Our Ref: TR010056

Application by Highways England for an Order Granting Development Consent for the A417 Missing Link Project

Advice following issue of decision to accept the application for examination

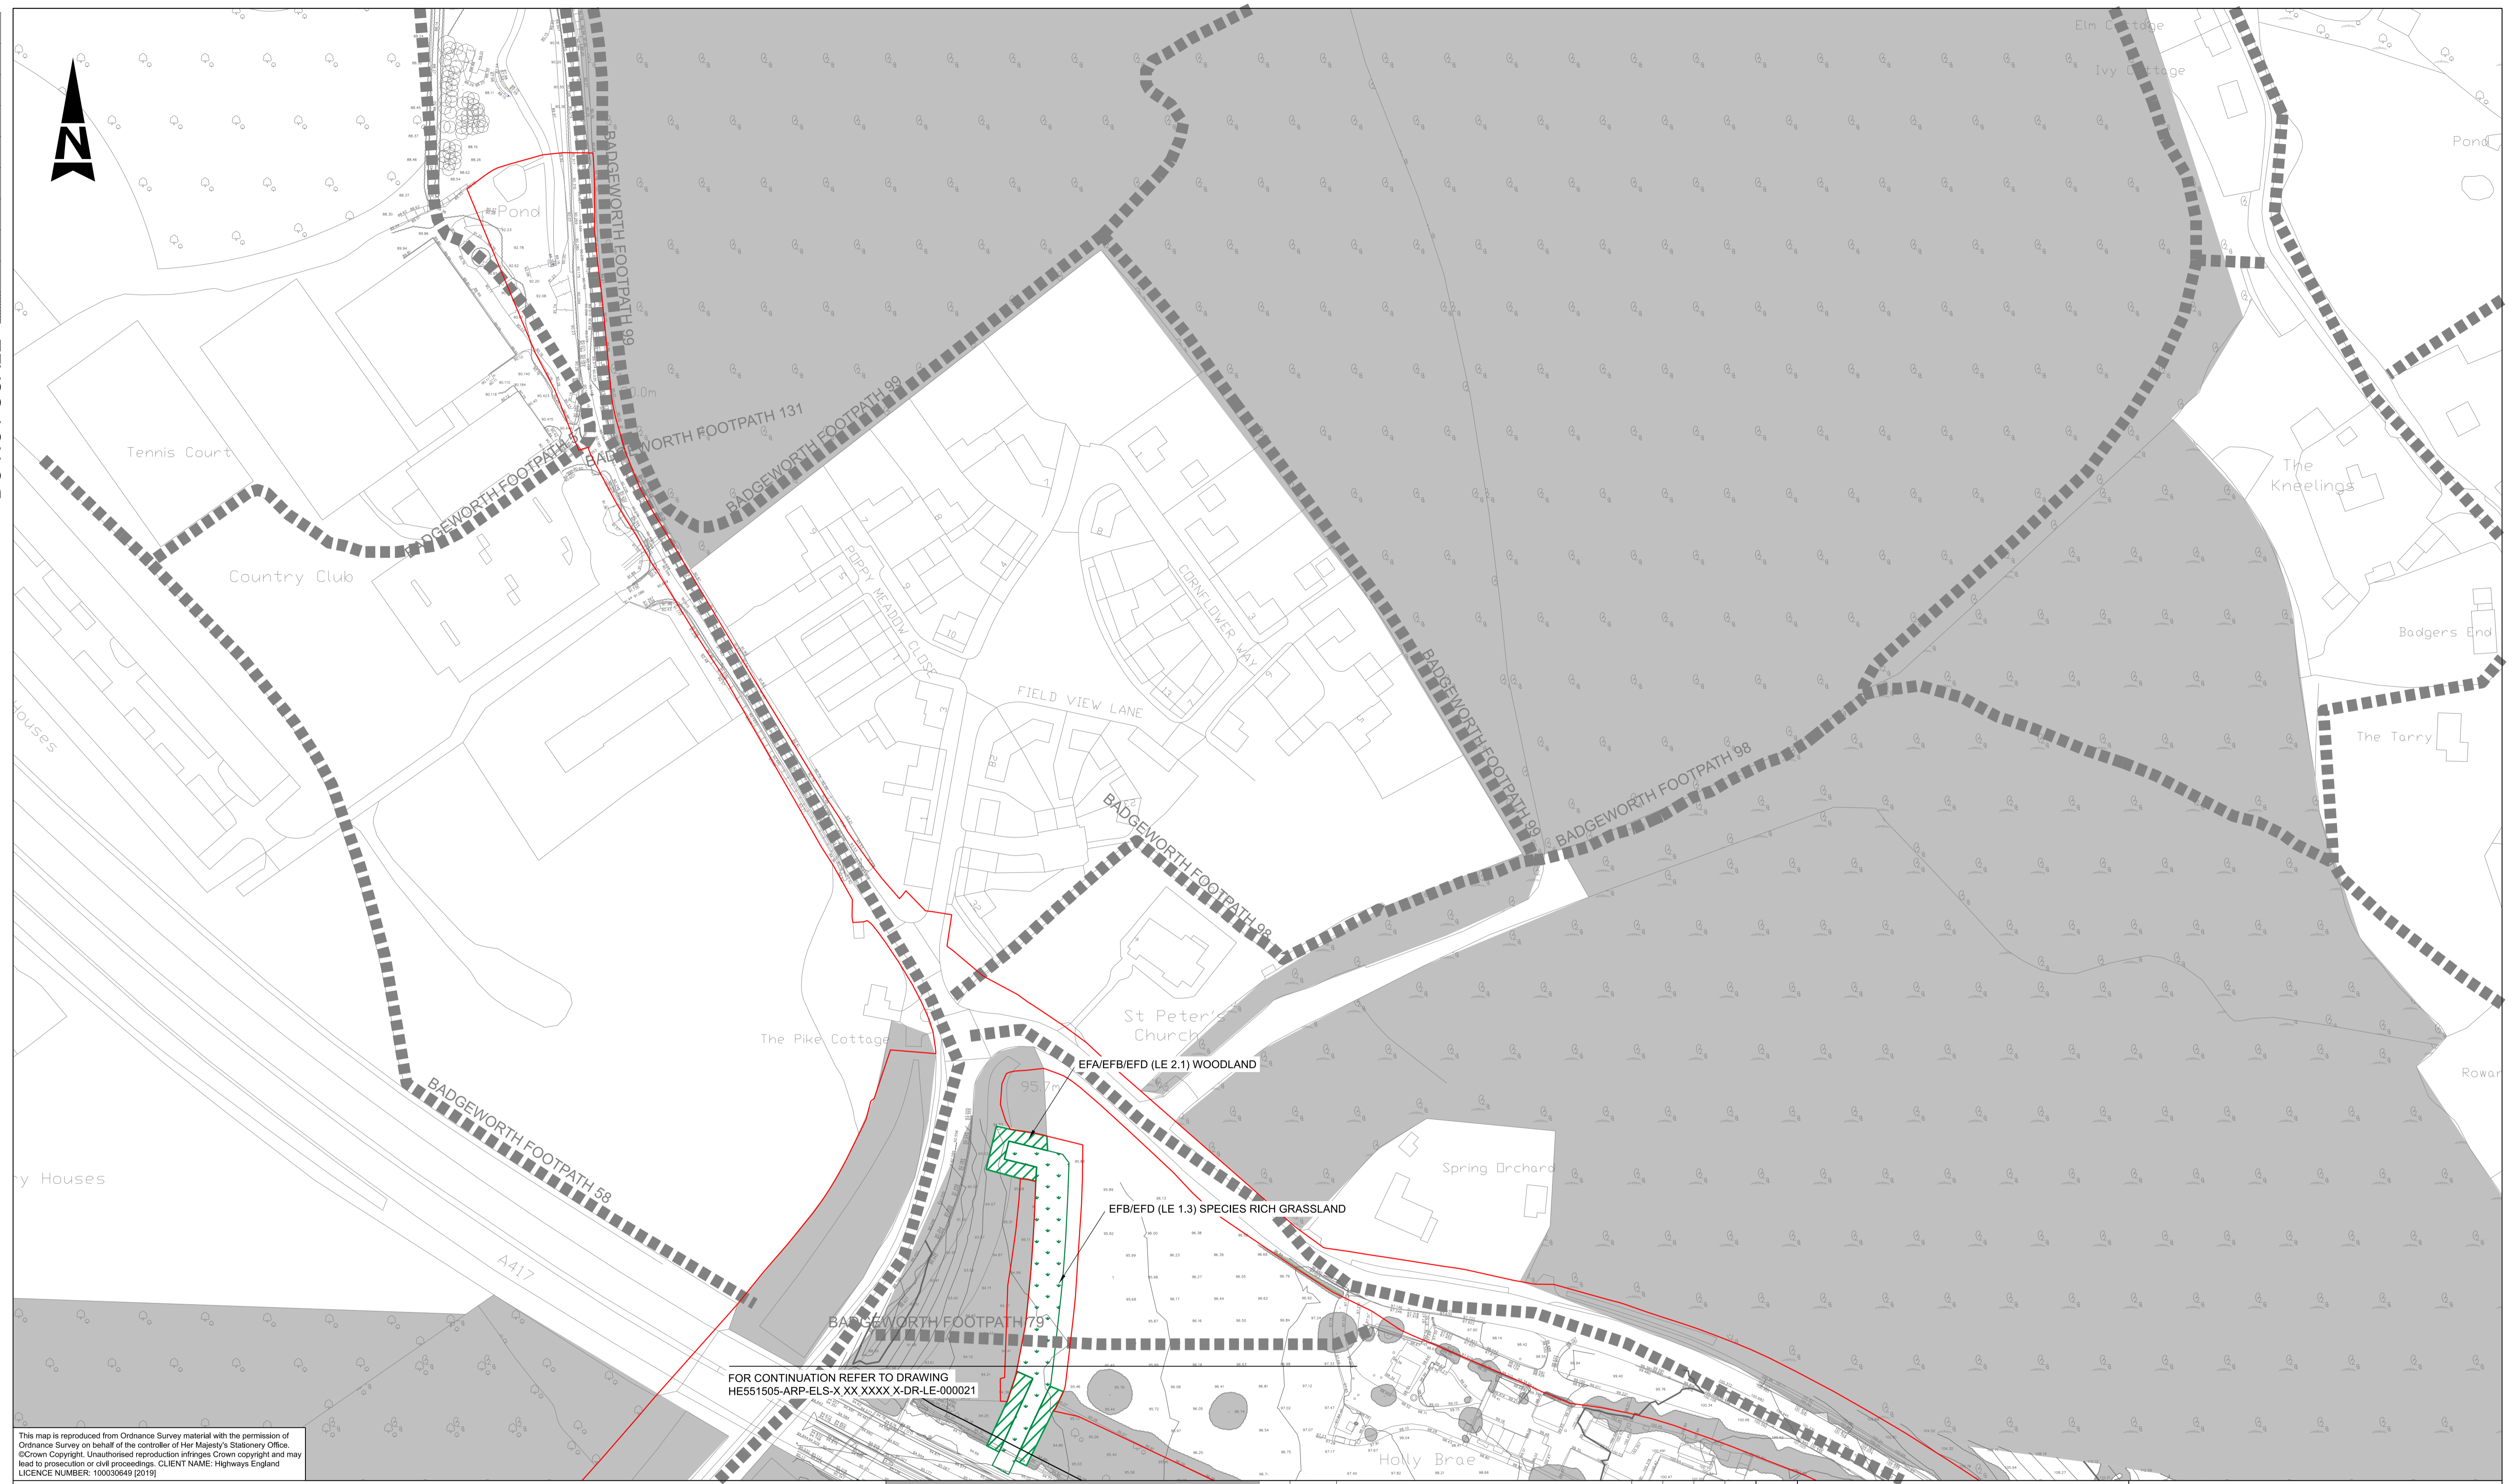
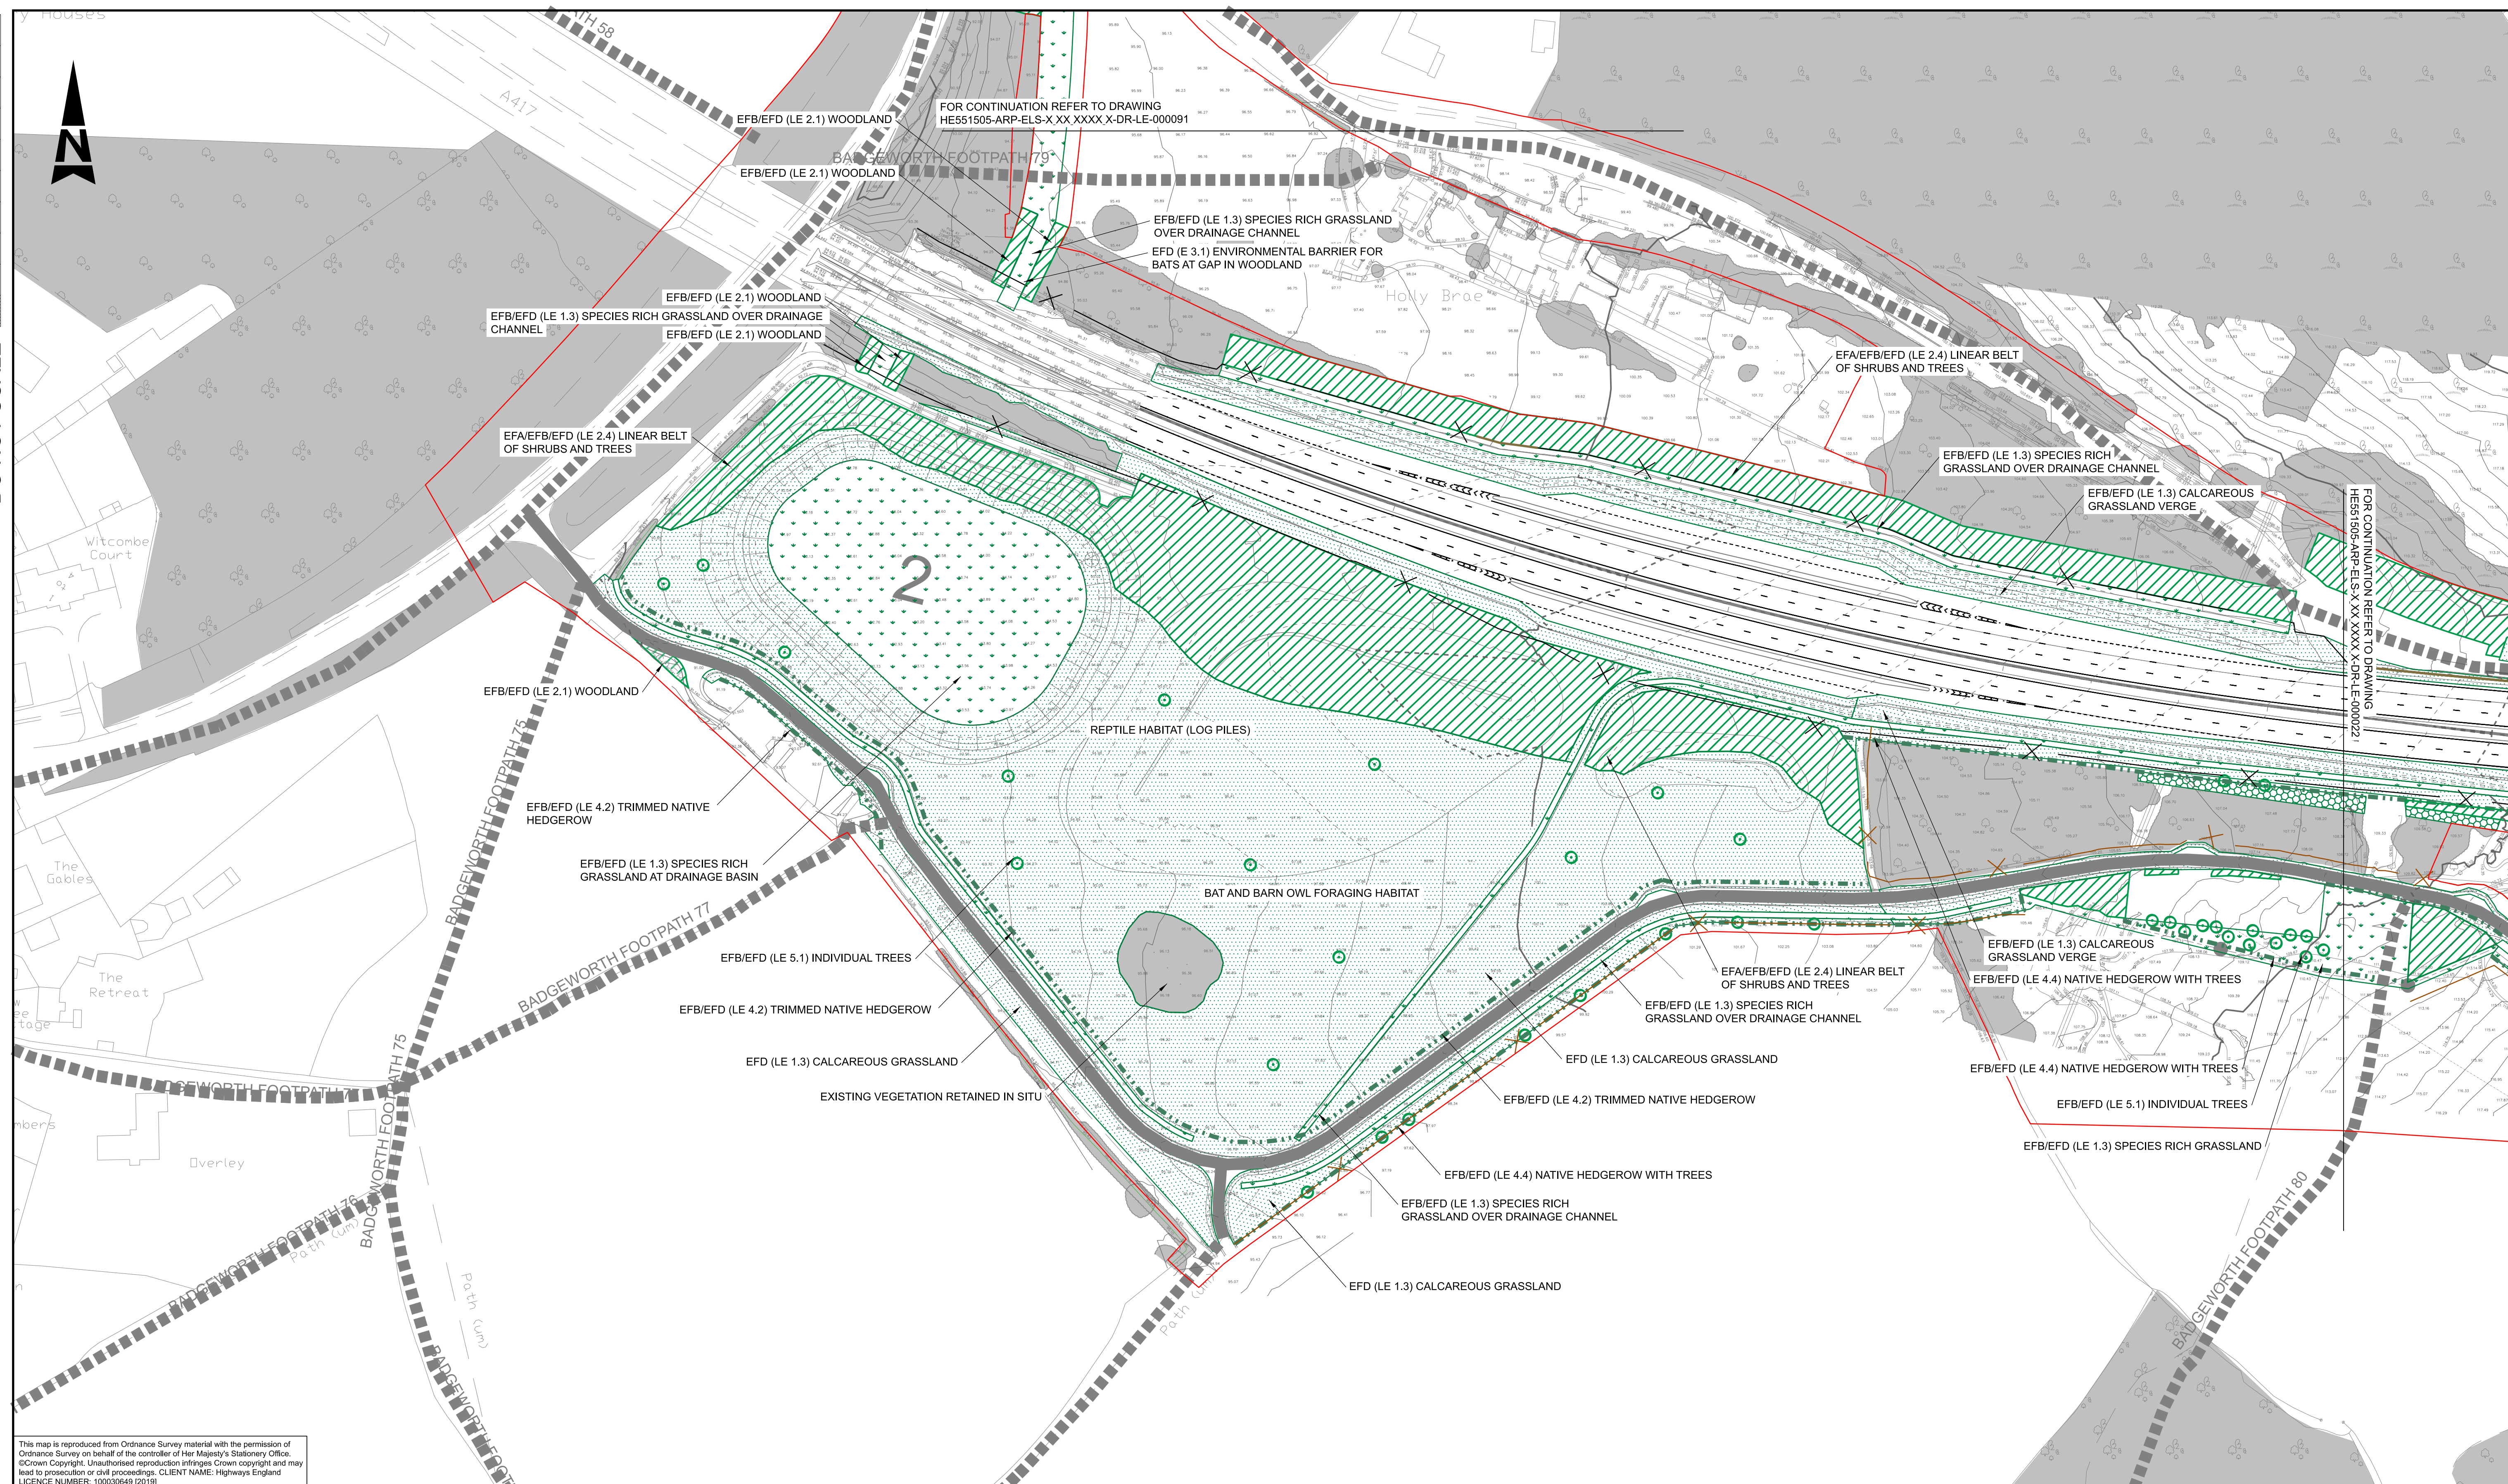
It would assist the future Examination if Sheets 1-6 included further high-level information about the scheme such as shaded areas of environmental mitigation and enhancement, retained woodland etc, as shown on the Environmental Master Plan (Figure 7.11).
